From: Tim Rodway | Rodway Planning [REDACTED]
Sent: 25 April 2019 11:14
To: Andrew Wood; Planning
Subject: Application LU/91/19/PL - Representation

Planning application reference: LU/91/19/PL

Change of use of parts of seafront for temporary food & drink outlets & other seaside uses together with associated temporary/portable structures & equipment for use by businesses associated with those outlets. Various sites along Littlehampton Promenade, Littlehampton

1.0 Introduction

THE SITE
(SITE B)

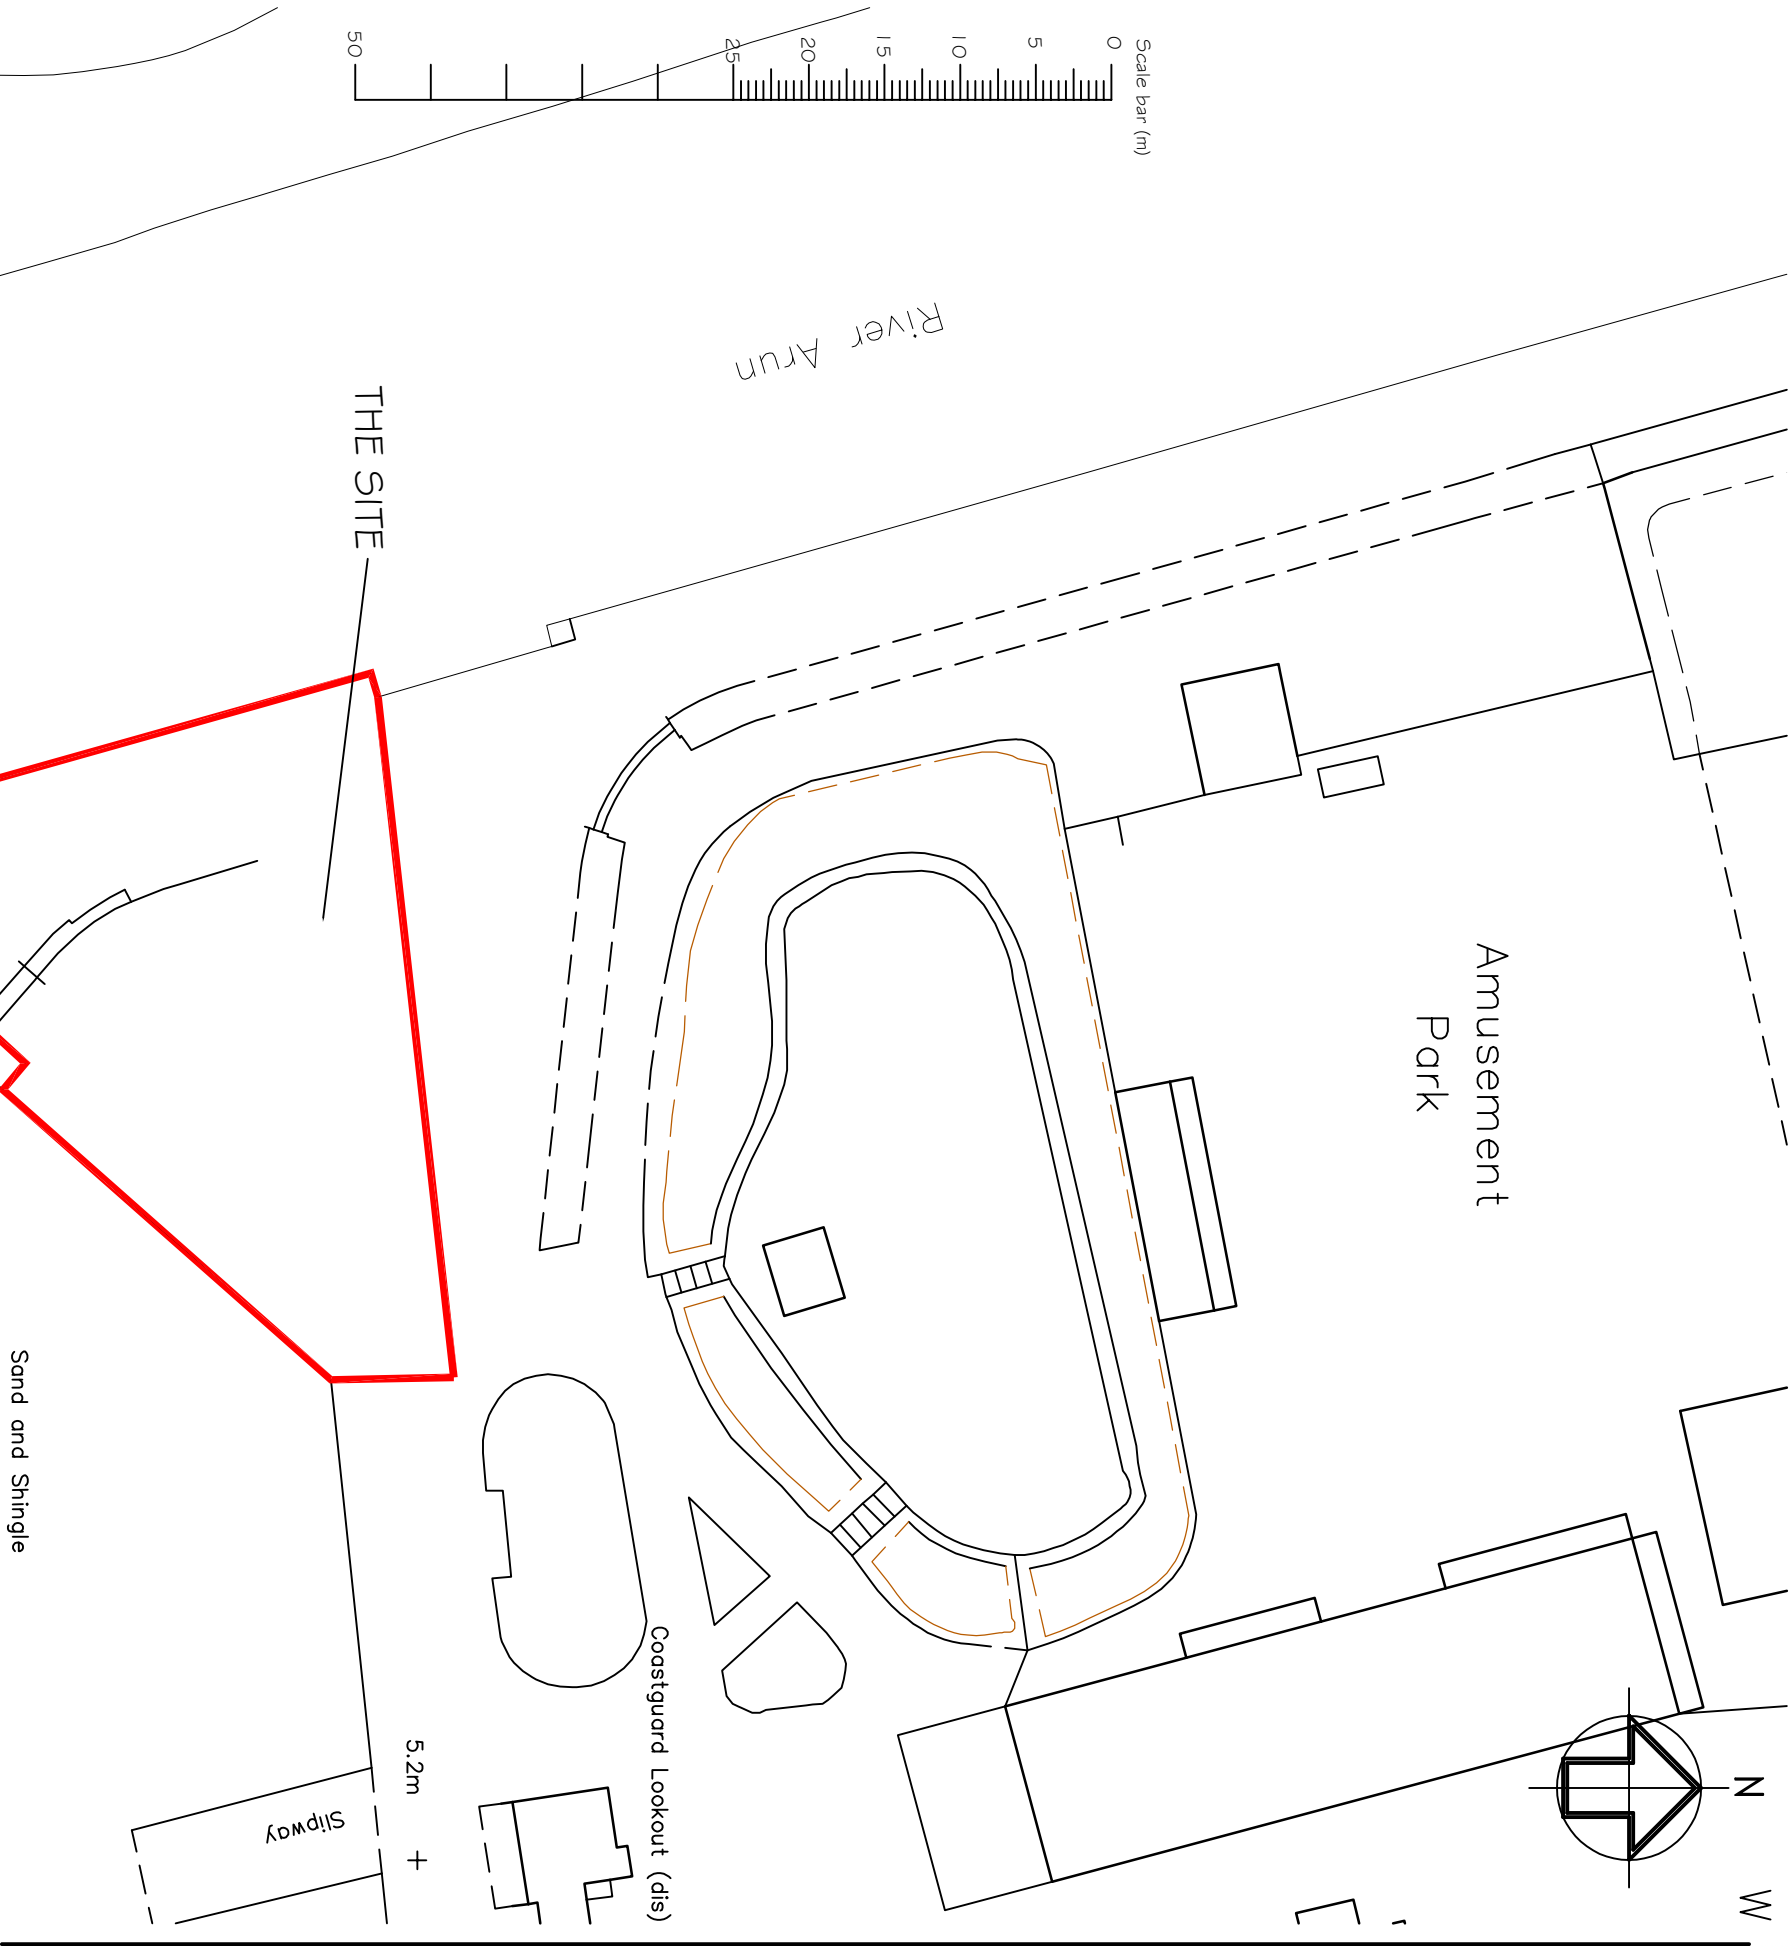
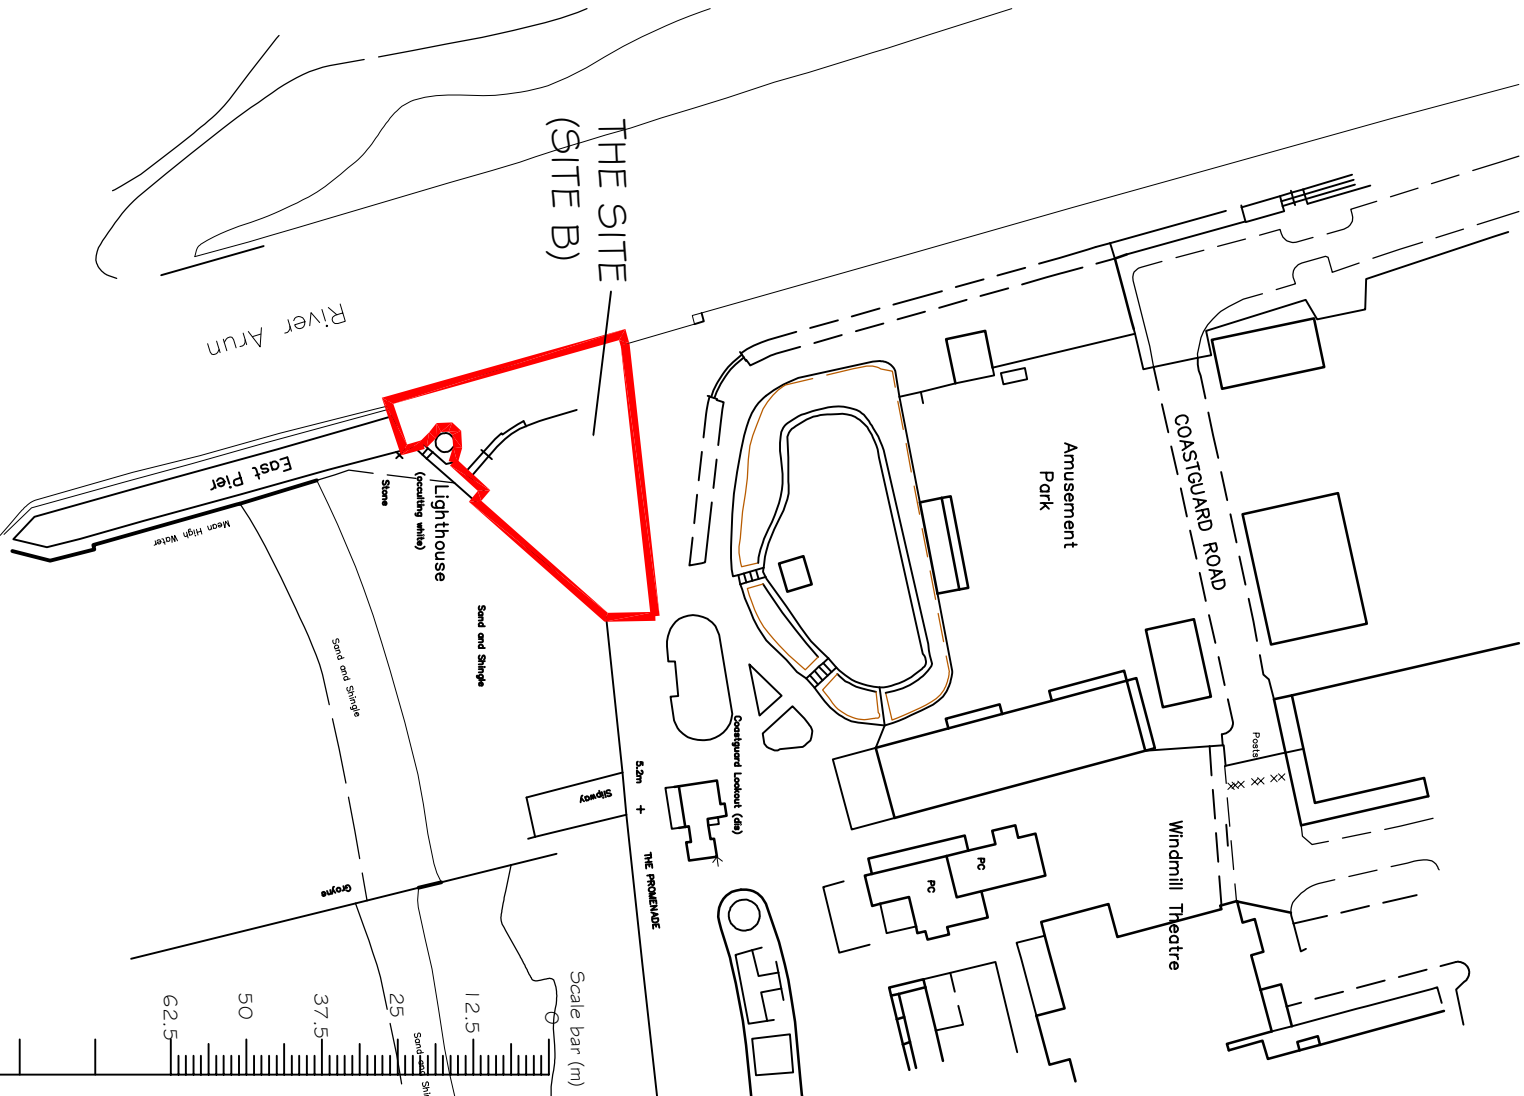
- 3.6 This site is in an extremely prominent location on the seafront lying on the eastern harbour arm immediately adjacent to the River Arun, as shown at Figure 2 below.

- 3.7 Clearly the site is very open, and provides an attractive focal point at the southern edge of the designated Green Link, and the western end of the promenade that runs along the seafront. The site is also visually important in that it provides an entrance to Littlehampton from the sea, and also provides open vistas from the west bank across a site of special scientific interest (SSSI) and the beach to the east.

- 3.8 The site is outside of the built-up area boundary, and as such countryside policies apply. The Arun Local Plan confirms that the Council will “*protect the natural environment by strictly controlling development in the countryside*”, and goes on to confirm that the countryside is an “*important designation*” (paragraph 7.2.1). The Local Plan specifies that “*the [built-up area] boundary is important in identifying the point of transition between the built form of a main settlement and the surrounding countryside. It is not simply a means of showing the limits of existing development, as some developed areas lie outside it and some undeveloped areas lie within it. In addition, the boundary also serves to preserve the setting of existing settlements from unnecessary development.*” Policy CSP1 permits development in the countryside subject to a number of criteria. We consider that development on Site B would not appear to comply with any of these identified criteria, unless it can be demonstrated that the new use would facilitate “quiet, informal recreation” as required by criteria (b). Due to the lack of information accompanying this application, we consider this to be far from assured.

- 3.10 In respect of Site B we also query why such a large area has been identified. This alludes to a more extensive use than that broadly indicated by the application description. Again, further clarity is required in order to provide comfort in this respect. Ideally, a more defined red line area should be submitted.
- 3.11 Essentially, without more detailed information relating to the proposed and extent of the use at Site B, then our stance is that we object to this element of the planning application, primarily due to potential impact on the open character of the locality.
